Our Case Number: ACP-324069-26

Re: Notification under Section 177AE of the Planning and Development Act 2000 as amended

Re: The Burrow Portrane Coastal Flooding and Erosion Risk Management (CFERM) Scheme

Figure 3.3: Archaeological assets DU008-028 and DU008-029 adjacent to and within project area, with proposed impacts overlaid

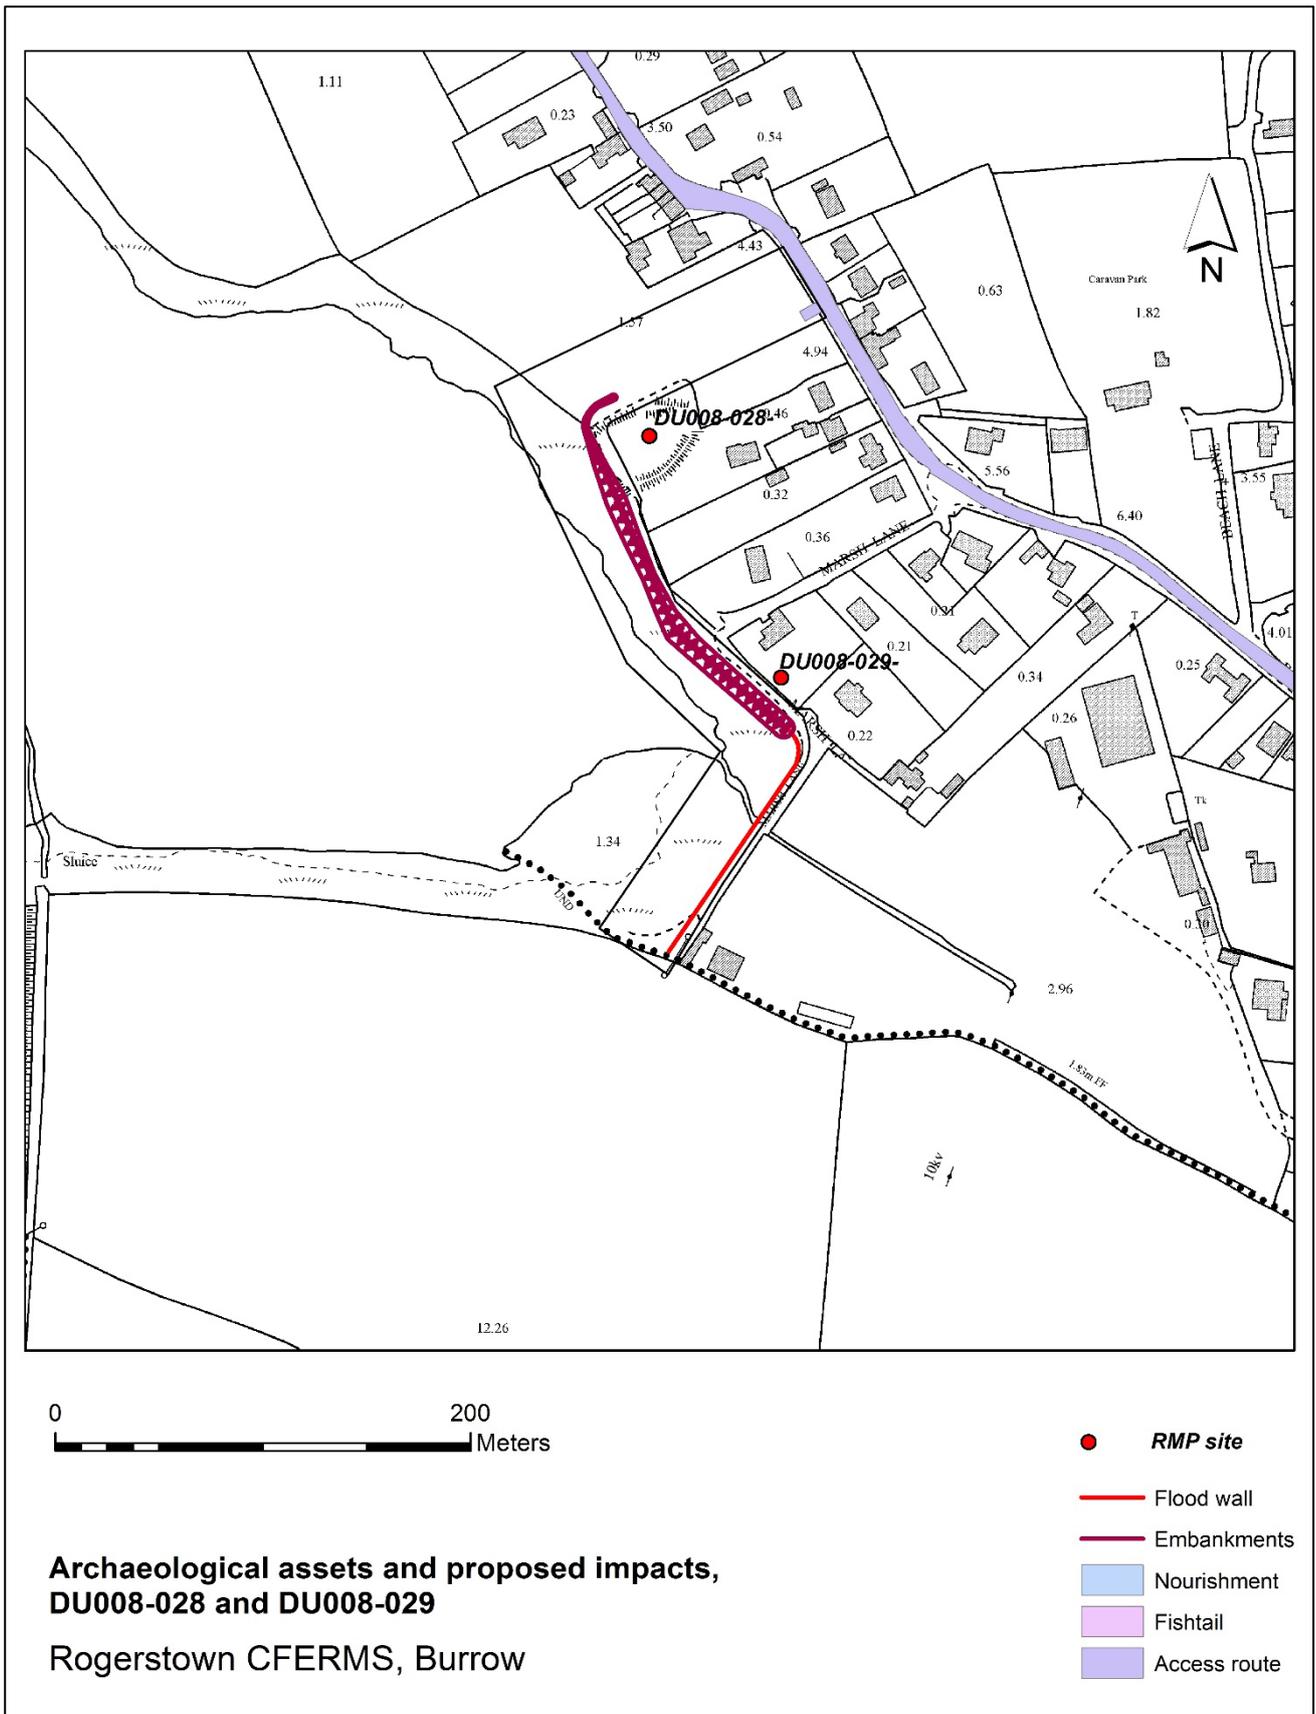
‘There will be no direct impact on either DU008-028 or DU008-029, which are protected structures and both of which lie outside the working area of the Proposed Development. However, care should be taken to ensure that both the R C Chapel site and the Holy Well site are protected from indirect impacts during construction. Should impacts, direct or indirect, be required at either DU008-028 or DU008-029 such works can only proceed with the permission of the NMS and FCC’.

Construction of the seven fish-tail Groyne Structures will directly impact the foreshore and potentially impact on previously unidentified buried shipwrecks, palaeolandscapes deposits and archaeological objects. Mitigation recommendations include pre-Construction phase archaeological recording of concrete flood wall on Marsh Lane; fencing to be erected at the Recorded Monuments DU008-028 and DU008-029; and Archaeological Monitoring of

by suitably qualified and experienced maritime archaeological personnel licensed by the Department. Whilst the EIAR states that impacts on DU008-028, Chapel and DU008-029, Holy Well and the newly identified historic Sea Wall (ADCO 2) will be avoided because they are outside the working areas, it also states that:

'should impacts on the above be unavoidable, a full archaeological survey should be conducted prior to impacts and subject to the approval of the NMS at DHLGH, and FCC'.

The Construction Environment Management Plan (CEMP) shall be updated to include the location of any and all archaeological or Underwater Cultural Heritage constraints relevant to the proposed development. The CEMP shall clearly describe all identified likely archaeological impacts, both direct and indirect, and all mitigation measures to be employed to protect the archaeological or Underwater Cultural Heritage environment during all phases of site preparation and construction activity.
